From: Juan Baeza
Sent: 30 August 2017 10:10
To: Planning.Responses
Subject: FW: A/87/17/L & A/88/17/HH - The Old Cottage, Station Road, Angmering BN16 4HY

From: Ian Wightman [REDACTED]
Sent: 22 August 2017 12:34
To: Russell McCourty
Cc: David Easton; Juan Baeza; Mark Jones; John Hinds; Liz Galloway; Emma Weaver
Subject: RE: A/87/17/L & A/88/17/HH - The Old Cottage, Station Road, Angmering BN16 4HY

PROPOSED FLOOR PLANS 1:50

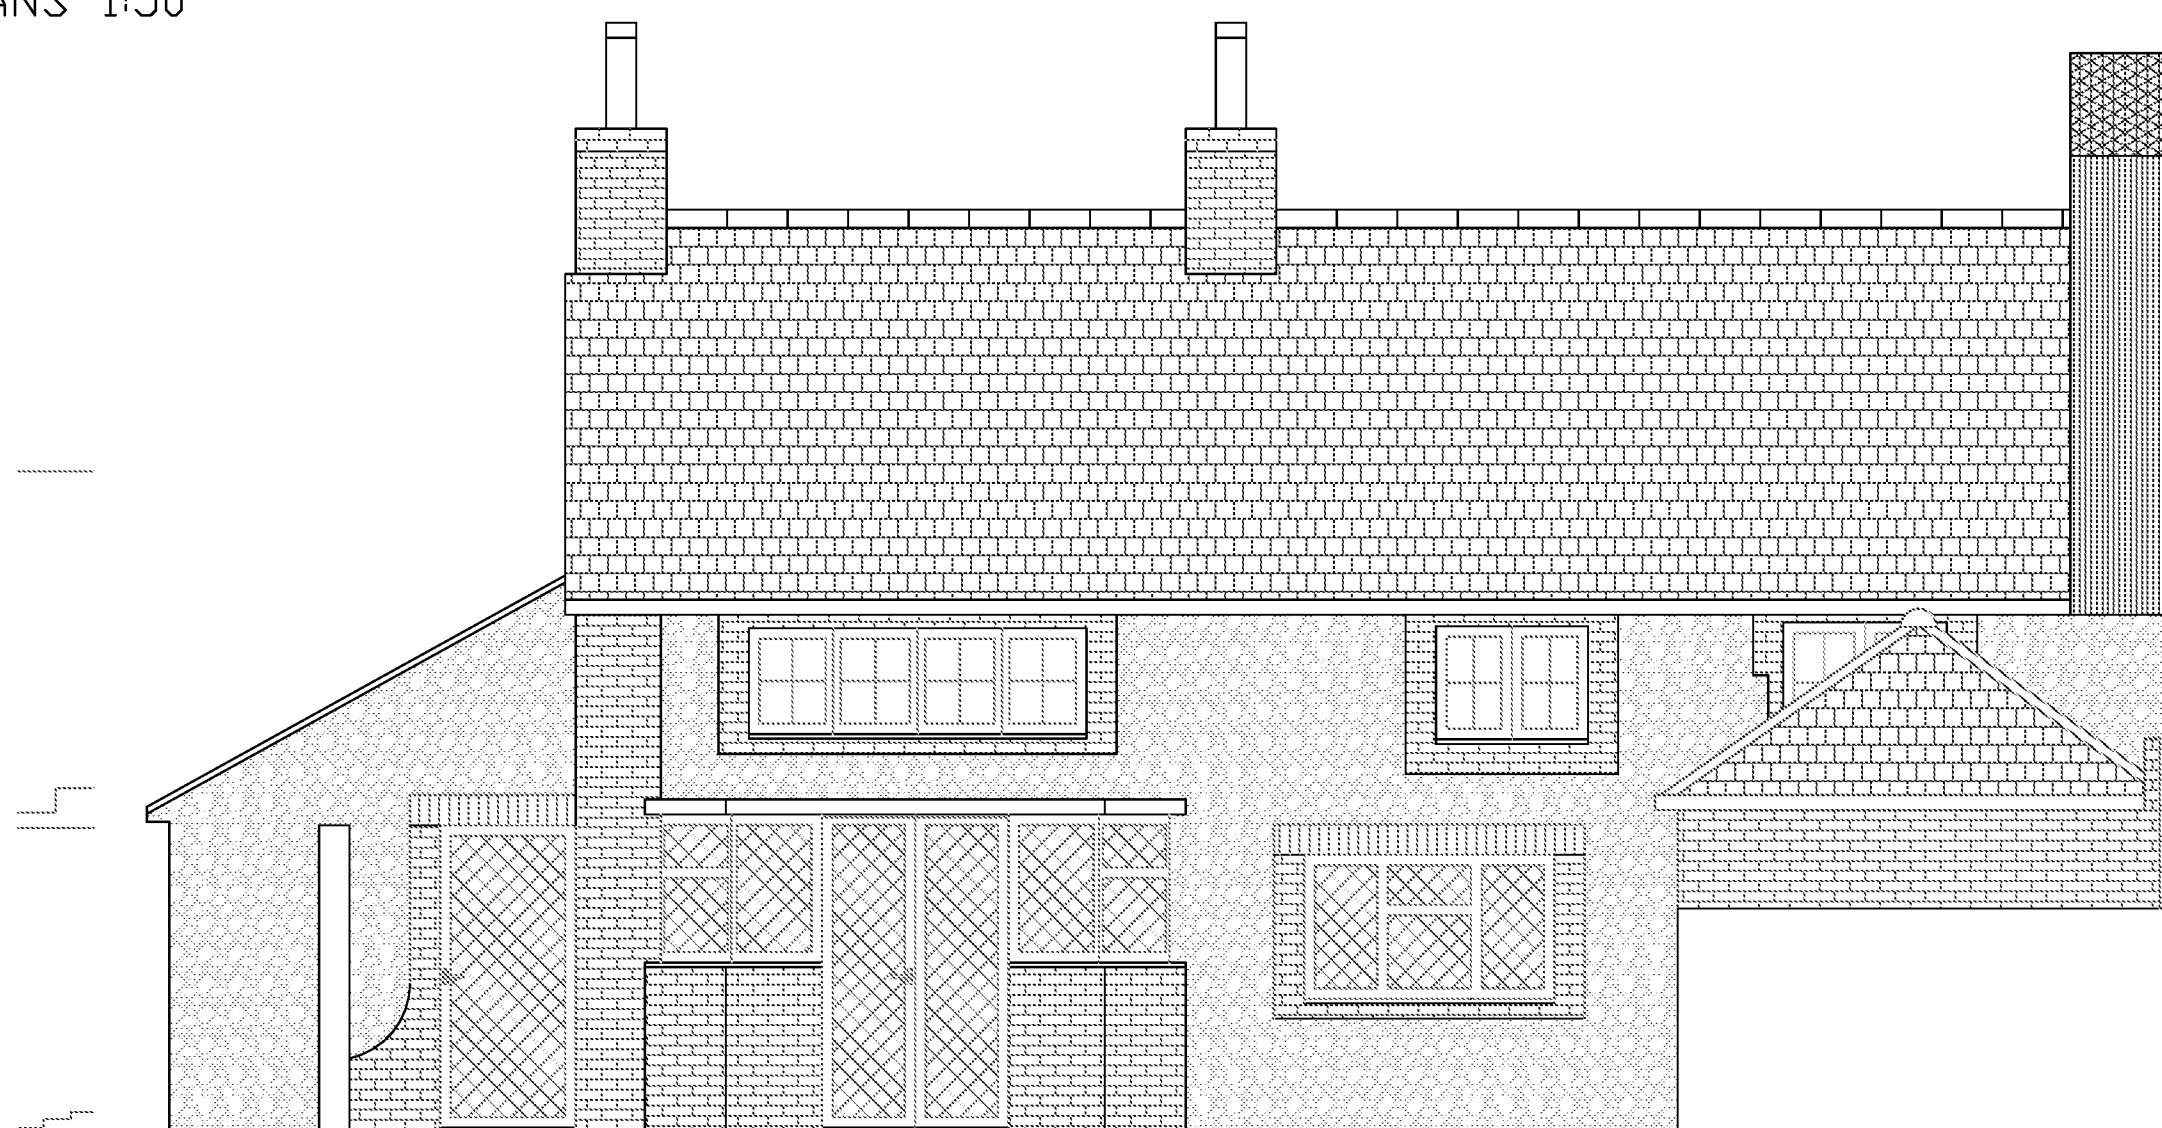
Thank you for the revised drawings showing amendments to the extension. Given the improvements to the south elevation we are now in a position to support this design.

We will require a condition for the brickwork and to this end you might want to consider Flemish or English bond which will add some interest without being too complicated.
